WEST SUSSEX COUNTY COUNCIL CONSULTATION

TO:	Arun District Council FAO: Hannah Kersley
FROM:	WSSC – Highway Authority
DATE:	6 October 2026
LOCATION:	Phase 6a Hampton Park Littlehampton
SUBJECT:	LU/249/25/RES Approval of reserved matters following LU/47/11/ (amended by LU/182/15) comprising 288 No residential dwellings, the formation SUDs features, children's play space, landscaping, car parking, roads, landscaping and public access to the northern extent of the Black Ditch Open Space. Substitute drawing pack plans and additional plans received.
DATE OF SITE VISIT:	n/a (desktop study undertaken as site visited previously)
RECOMMENDATION:	More Information Required

This is the **second** WSSC Highways response to the above planning application seeking approval of reserved matters following LU/47/11/ (amended by LU/182/15) comprising 288 No residential dwellings, the formation SUDs features, children's play space, landscaping, car parking, roads, landscaping and public access to the northern extent of the Black Ditch Open Space.

scheme: Hampton Park
Littlehampton
client: Persimmon Thames Valley
drawing: Hard Landscape
date: November 2025
scale: 1:200@A1
drawing no: PERTV24807 14 - Sheet 3 of 11
drawn: RP checked: RH

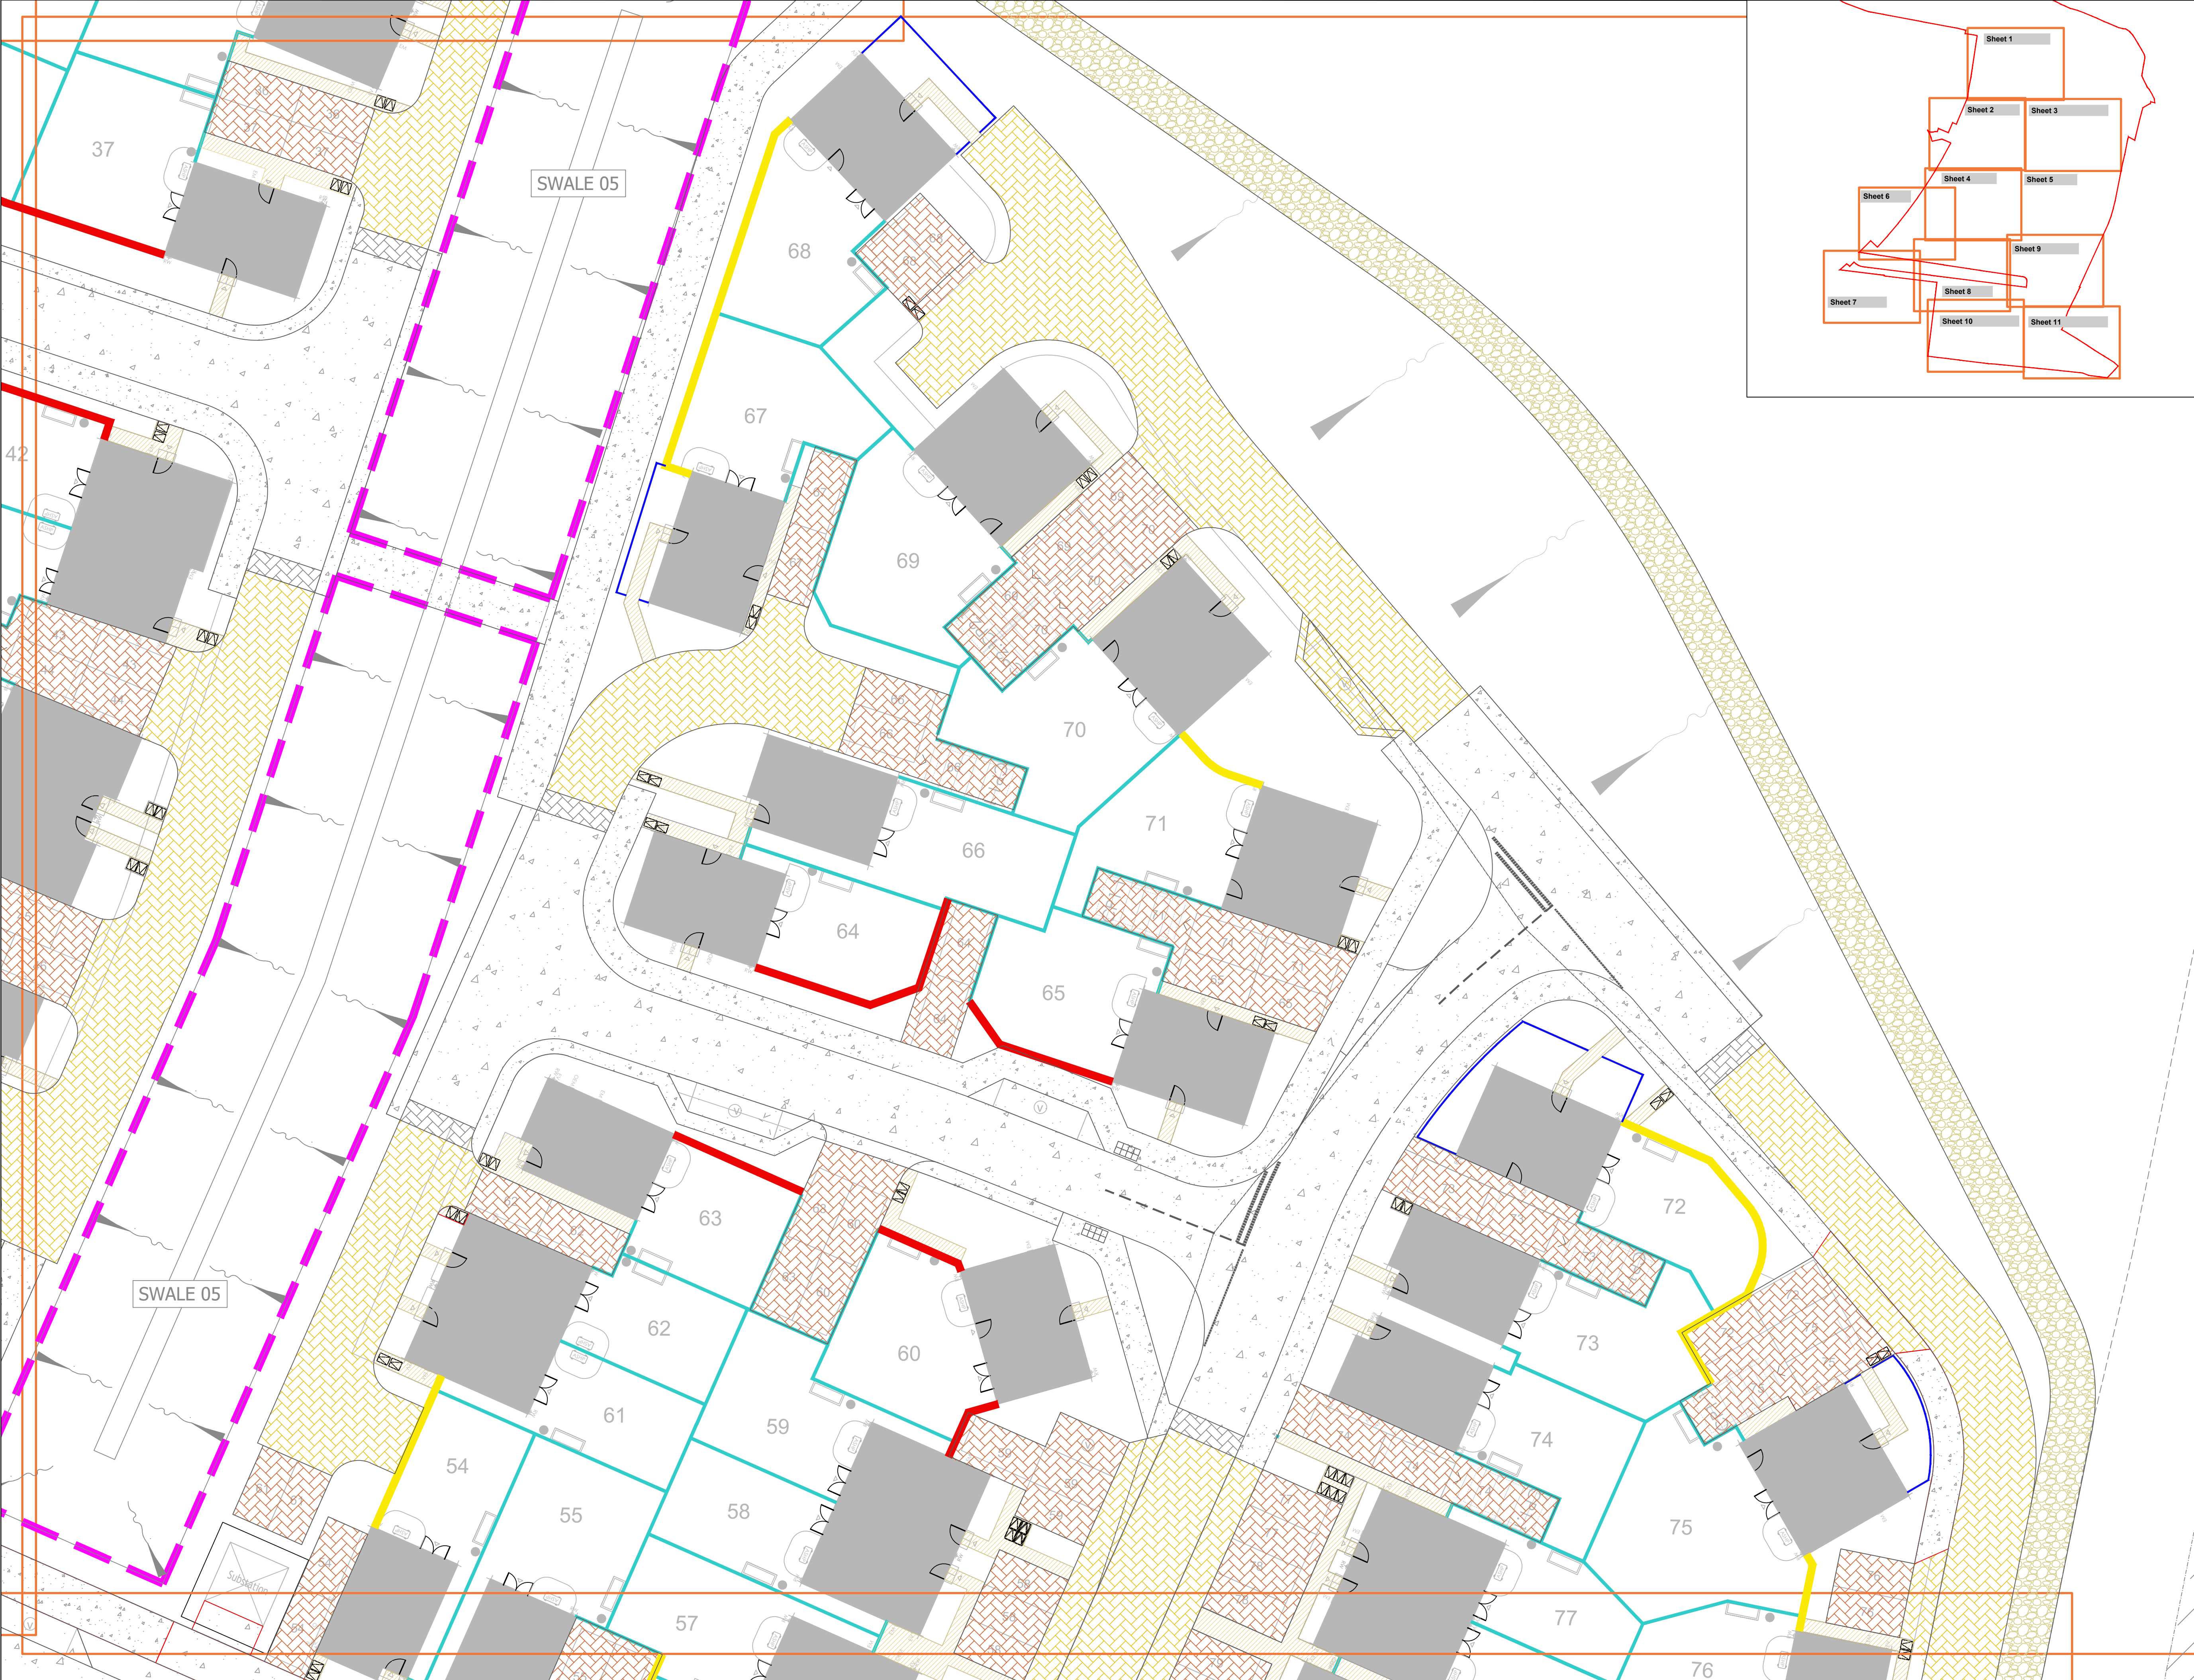
- Planting should not obstruct forward visibility of junctions (sheet 3, x1 hedgerow). **Hedgerow is still shown in the northern-most red-edged location shown below. This should be removed.**

- Figure 1 – Screenshot of sheet 3: Annotated to show hedgerows within areas likely to be offered for highway adoption and containing hedgerow planting (note the northern hedgerow is within the assumed indicative visibility splay shown). Hedgerow to be removed from the plans. **Hedgerow is still shown in the northern-most red-edged location shown below. This should be removed. For the southern-most red edged location, the hedge should be squared-off to ensure that visibility for users of the parking bay and for pedestrians crossing at this point is maximised. Please see extract above circled in blue (applicable to the southern hedgerow).**
